# WOODMOOR WATER AND SANITATION DISTRICT NO.1

## LAKE PUMP STATION NO. 2 AND TRANSMISSION PIPELINE

### GRADING AND EROSION CONTROL PLAN

PPR-21-019

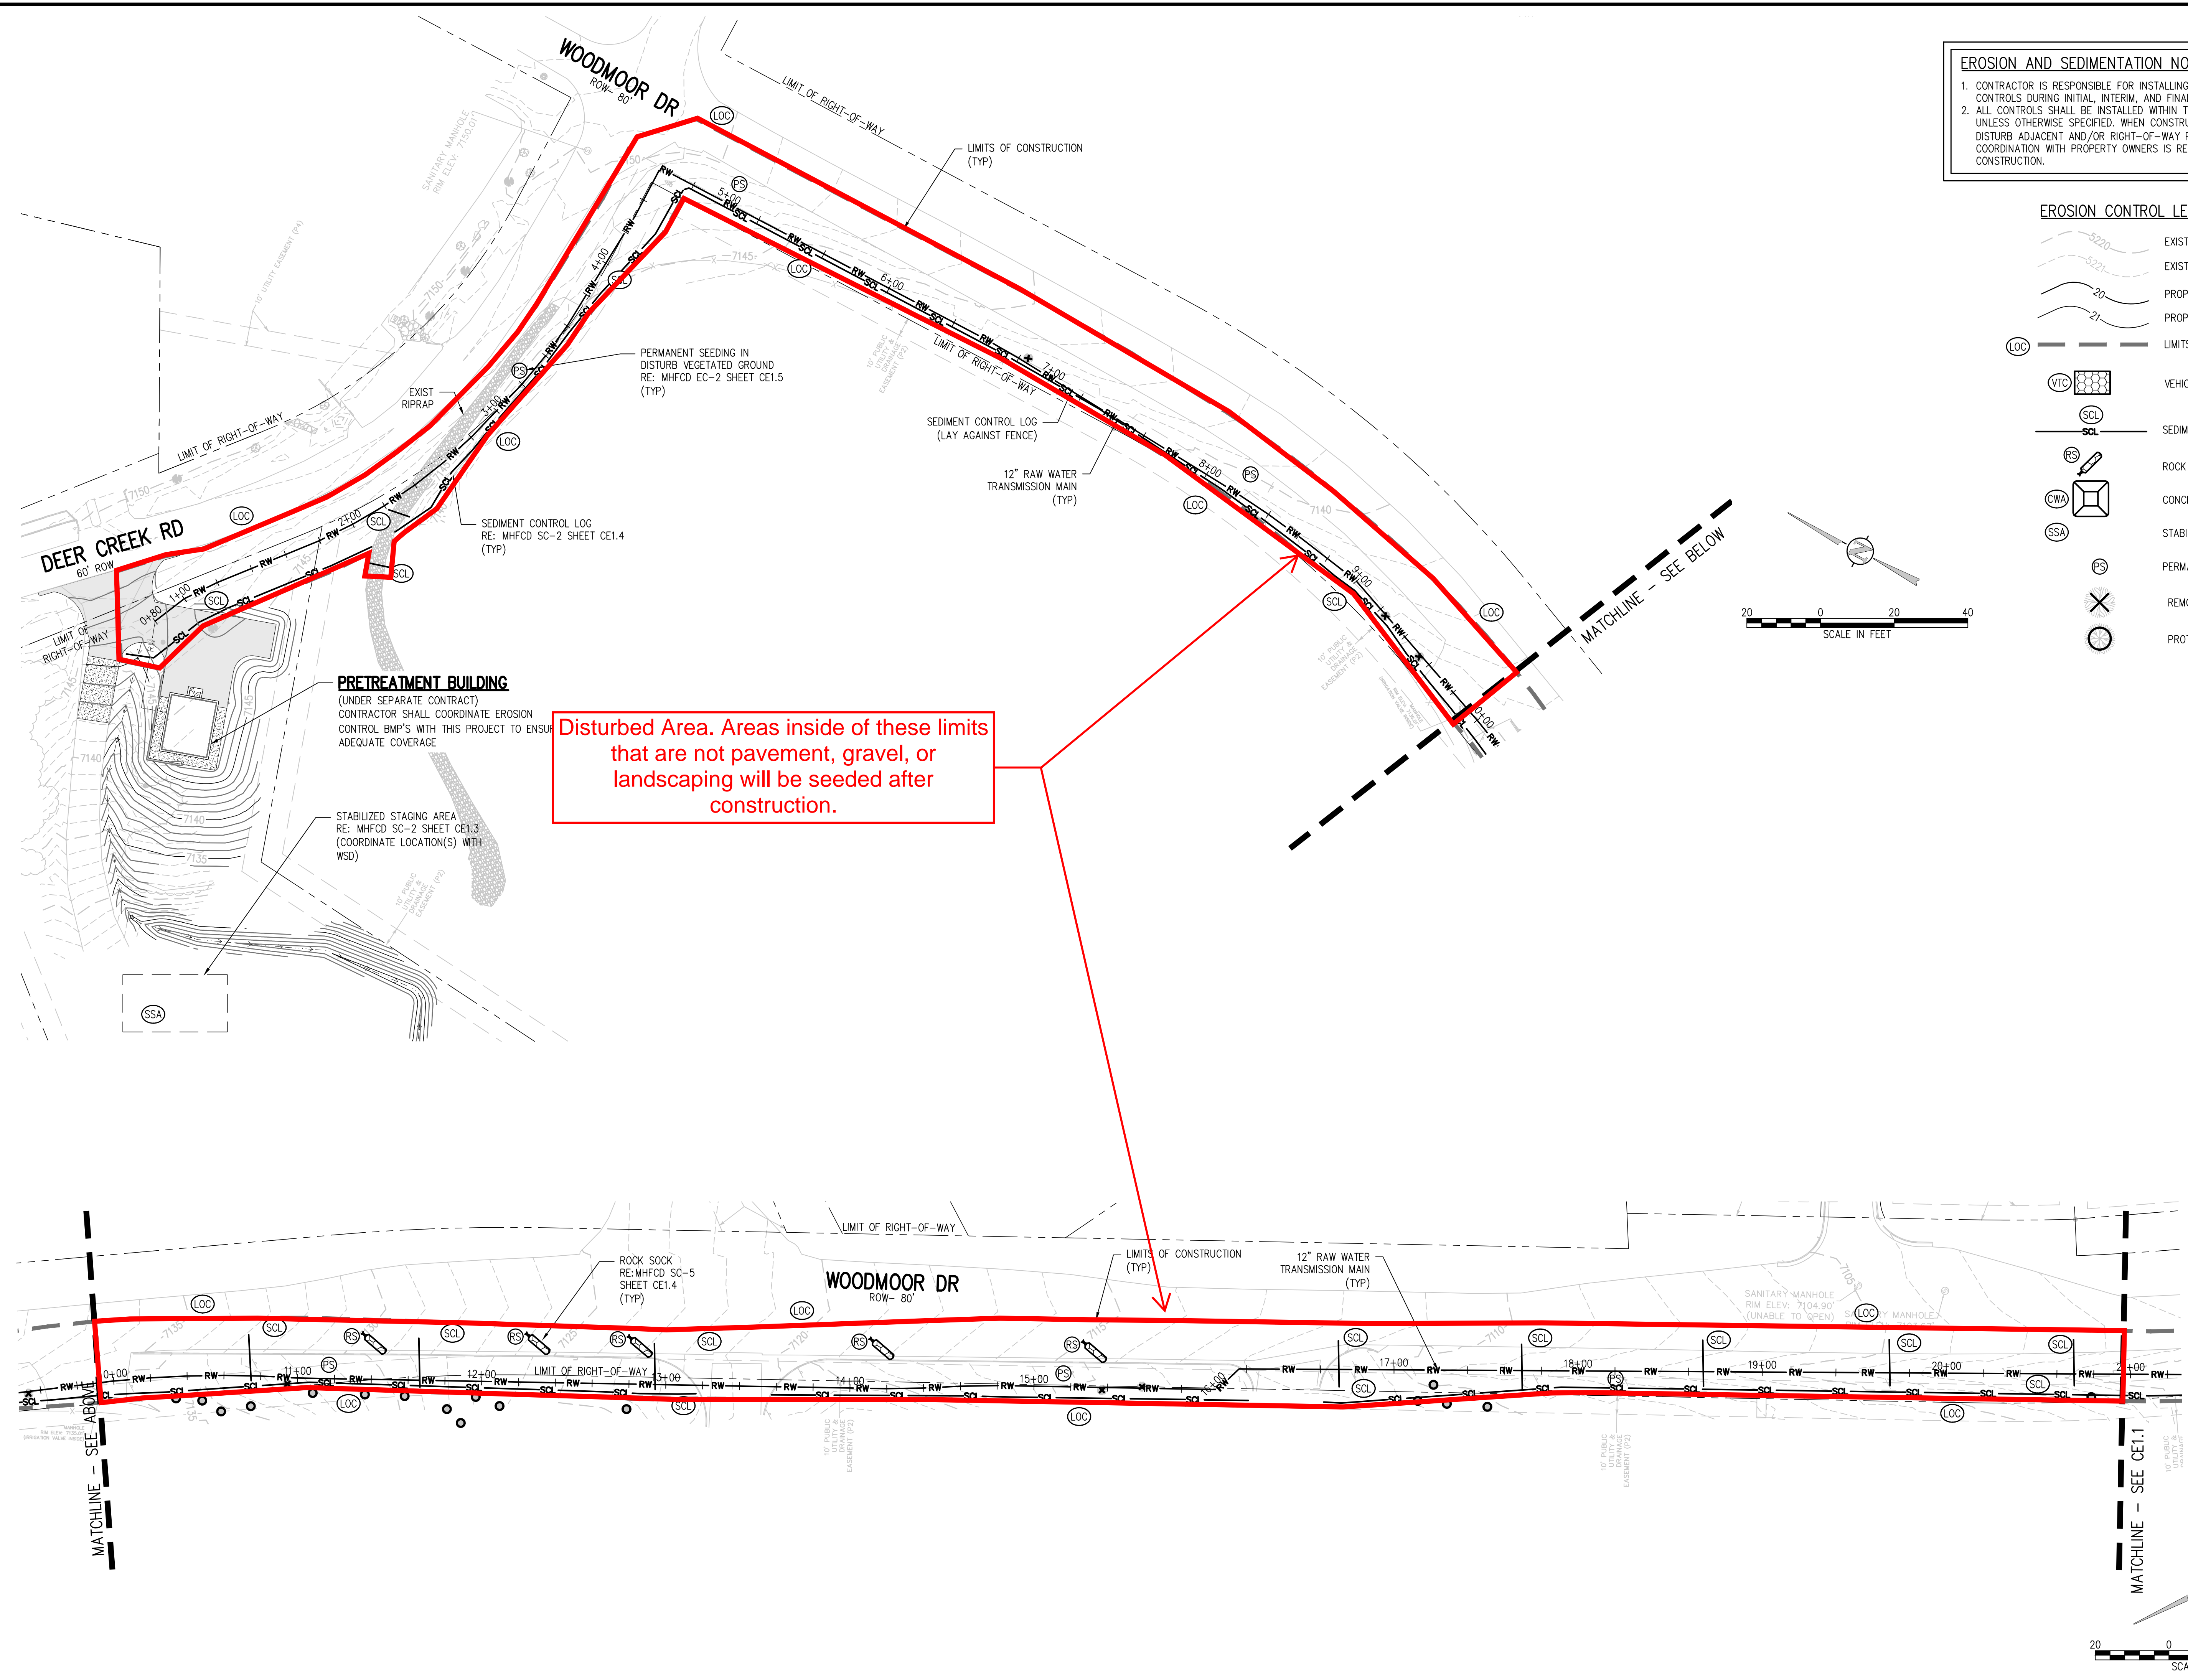
Typical all sheets:

- Checklist item "T" - Label specific areas on plans or just make a general note regarding condition of existing vegetation within limits of disturbance.
